## **Additional submission by Linda Twohey following Issue Specific Hearing 5, section 3.2, comments on glint and glare effects on residential properties**

1. I wish to expand further my comments made at ISH 5, on item 3.2, about the Applicant's assessment of glint and glare effects on residential properties, taking as an example, property R11 at New Lodge Barns, Walgrave. (See Fig 5.2, APP-155).

Title: Figure 8.7.1 Visual Receptors
Green Hill A & A.2

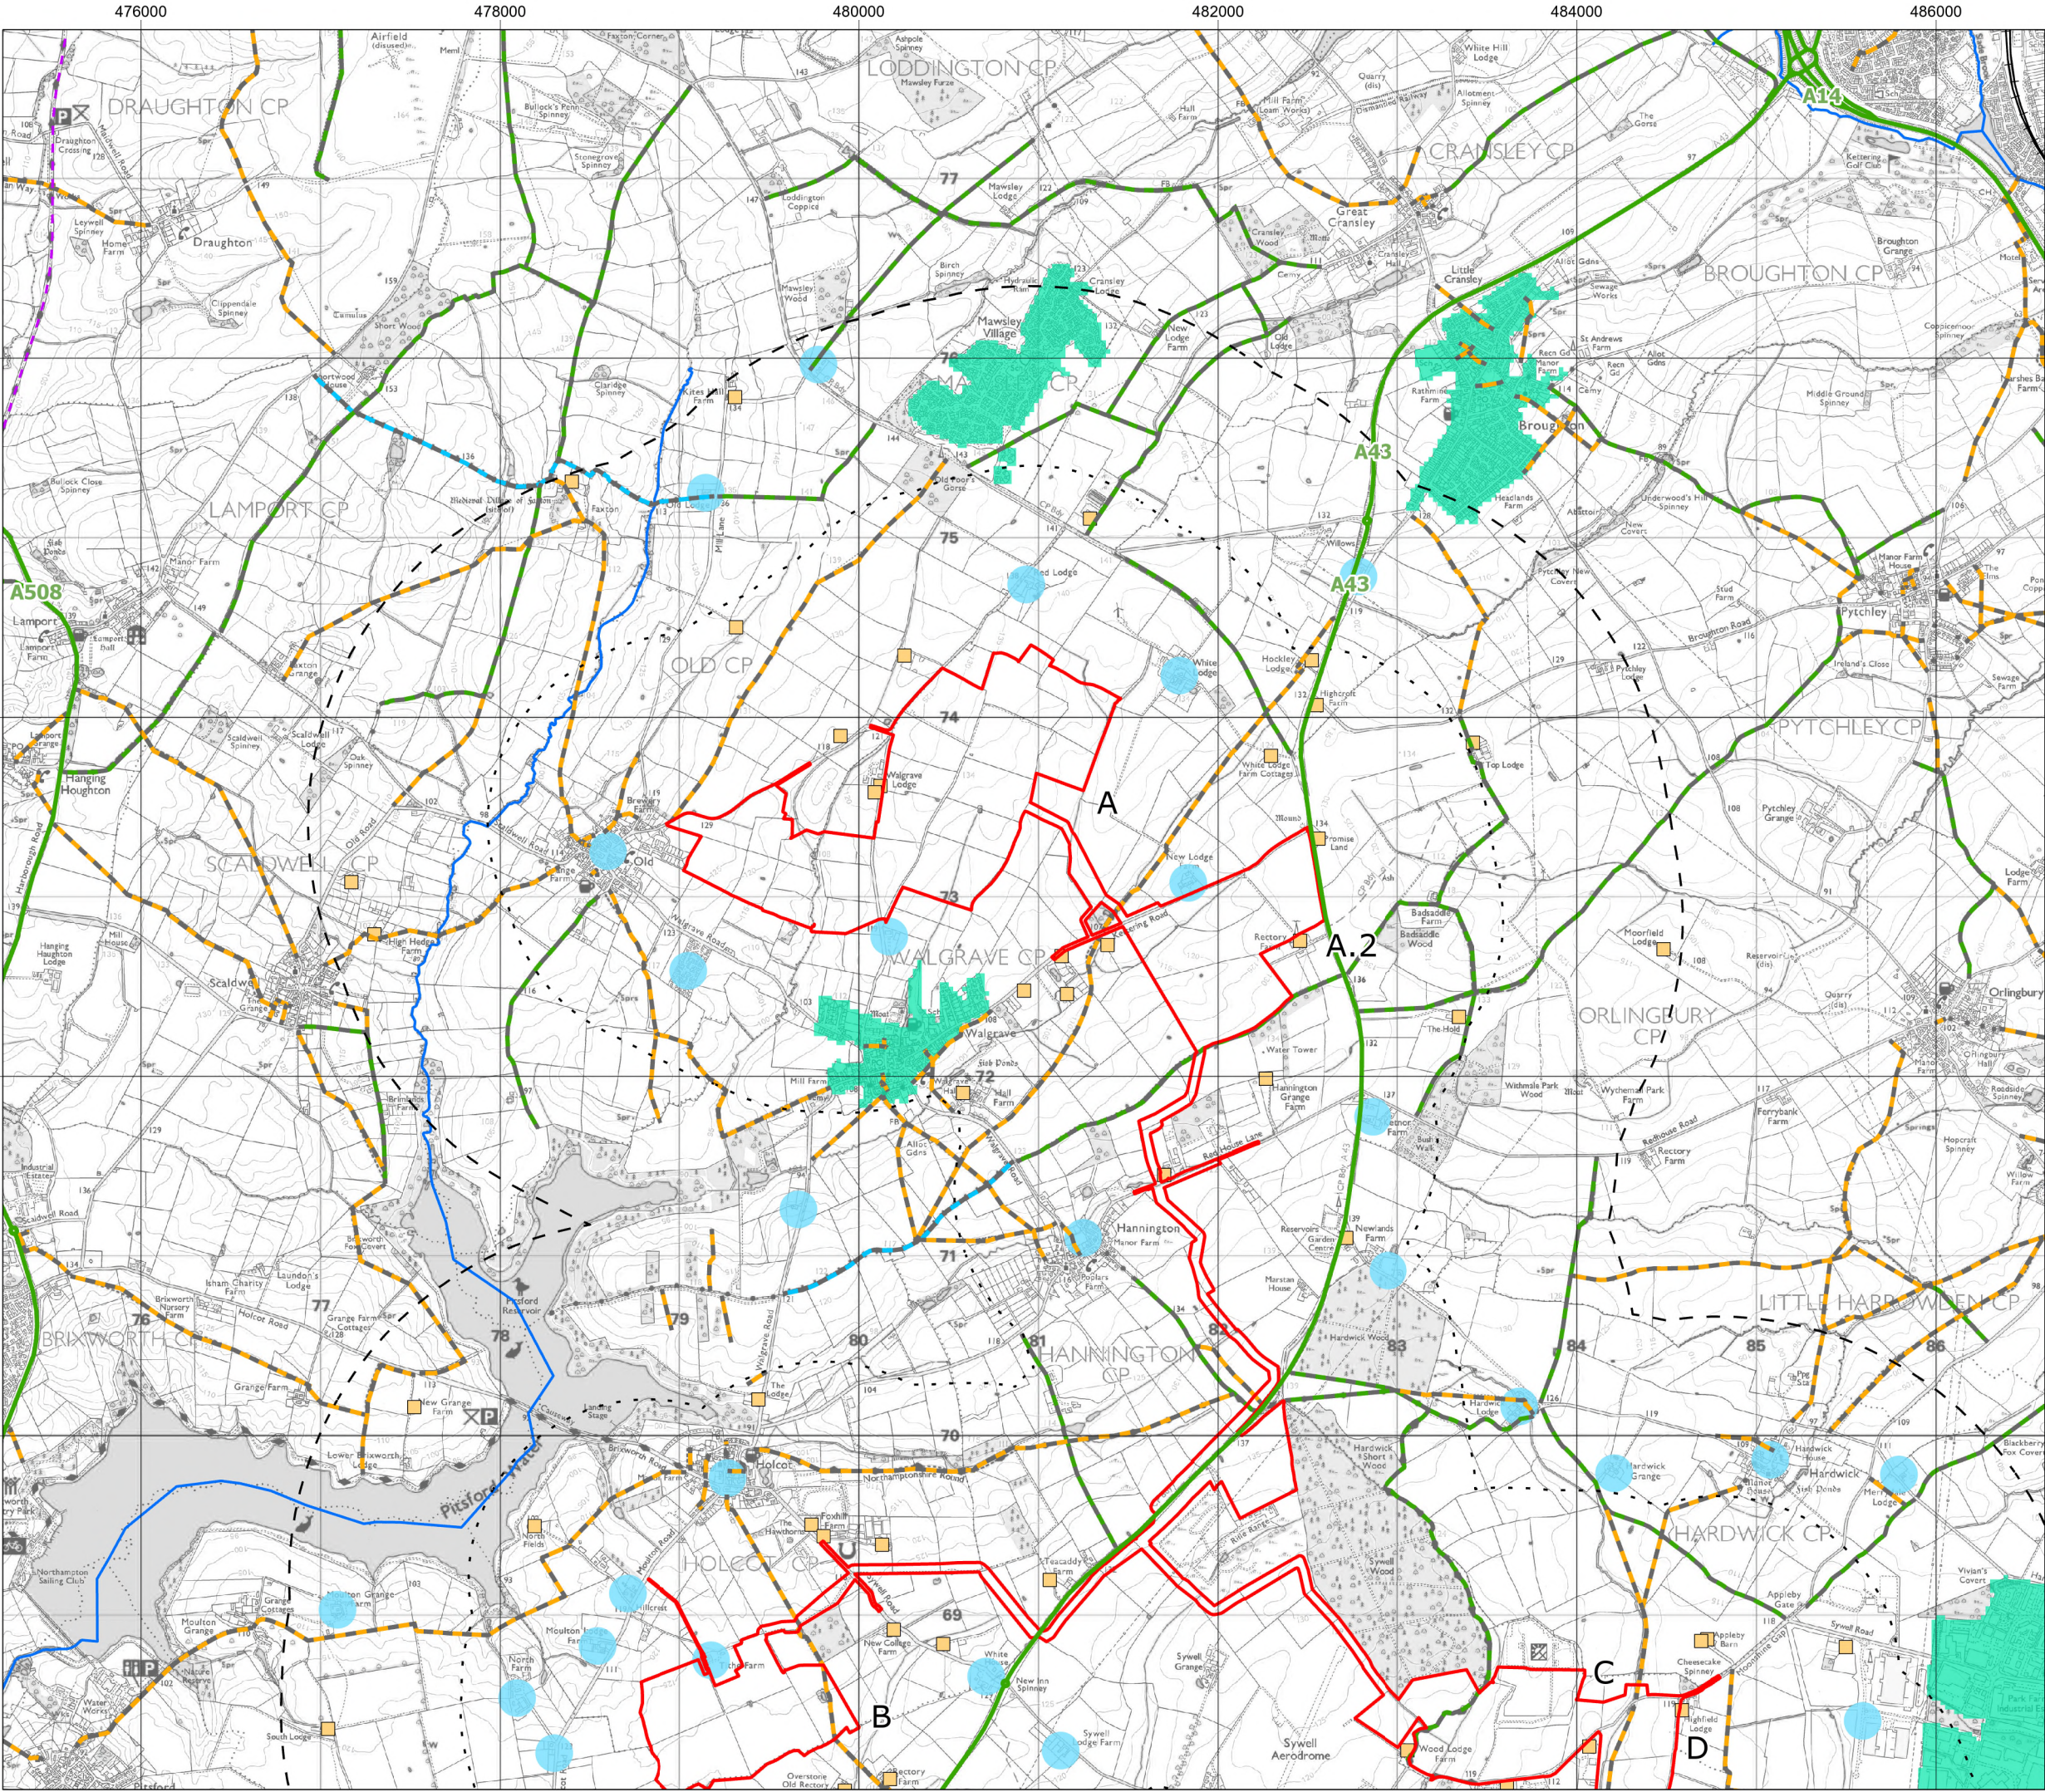
3. According to my calculations, using the Applicant's modelled data, if fixed panels are deployed, R11 will experience:  
Glare for >6 months per year, from both Sites A and A2, with 50 – 55 minutes of glare for at least 5 months, occurring both morning and early evening.

4. If tracking panels are used:  
Glare for >6 months per year, minimum 30 minutes per day, from Site A and/or A2, 50 – 55 minutes glare for at least 5 months, occurring both morning and early evening.

evidently inappropriate for residential properties where it cannot be assumed that receptors in upper level rooms are not subject to any adverse effects, particularly as the timing of glare with both types of panel will tend to be early morning and early evening. Also, many residential properties are now used as offices for working from home.

7. In Results discussion, 6.1.3, (APP-155) a photograph has been taken from the Kettering Road opposite R11, Figure 6.4, directly into the existing hedgerow, which appears to have been chosen for its particularly high vegetation, not representative along this stretch of road.

8. It states 'Line of sight from PV3 Green Hill A towards R11 is expected to be obstructed by PV2 Green Hill A. Furthermore, line of sight between R10 and PV2 Green Hill A is obstructed by intervening topography'. I cannot find any diagram which explains which fields of Site A are in each of PV1, PV2 and PV3, so are unable to assess this myself. But surely the modelling has already taken topography into account in its calculations of angles of glare? If not, how much confidence can be placed in these results, across all of the Glint and Glare assessments, on residential, road users and aviation?

9. The Applicant then concludes that the line of sight from R11 towards the remaining panels of Site A and all of Site A2 will be obstructed 'by vegetation that is to form instant screening as part of embedded mitigation for the Landscape and Visual Impact Assessment'. Reference to APP-208 shows that native tree and scrub planting, instant screening, is planned for the side of A2 opposite R11. However, the land is rising, so any effects are likely to be limited. Reference to APP-207, shows that no instant screening is planned at all for the east side of Site A which faces towards the properties including R11 at New Lodge Barns.
